**KIRKLEES METROPOLITAN COUNCIL
INVESTMENT & REGENERATION SERVICE**

DELEGATED DECISION TO DETERMINE PLANNING APPLICATIONS

Reference No:	2025/62/90893/E
Site Address:	7, Frank Lane, Thornhill, Dewsbury, WF12 0JS
Description:	Erection of single storey front extension, two storey side extension, part single storey/part two storey rear extension with associated external alterations.
Recommending Officer:	Nicole Helliwell

Officer Report

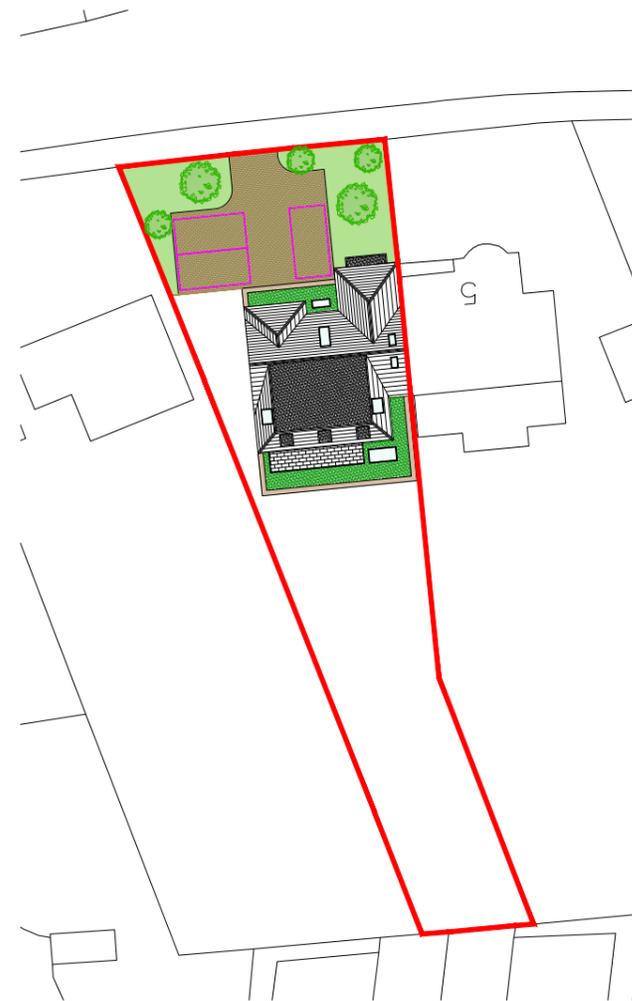
The proposed works would intensify the domestic use at the dwelling. However, the submitted block plan demonstrates that sufficient space would be retained within the driveway for three vehicles which would represent a sufficient provision for a five bedroomed dwellinghouse. Therefore, the development is considered acceptable in accordance with Policies LP21 and LP22 of the KLP, Chapter 9 of the NPPF, Principles 15 and 16 of the Kirklees House Extensions and Alterations SPD and the Highways Design Guide SPD.
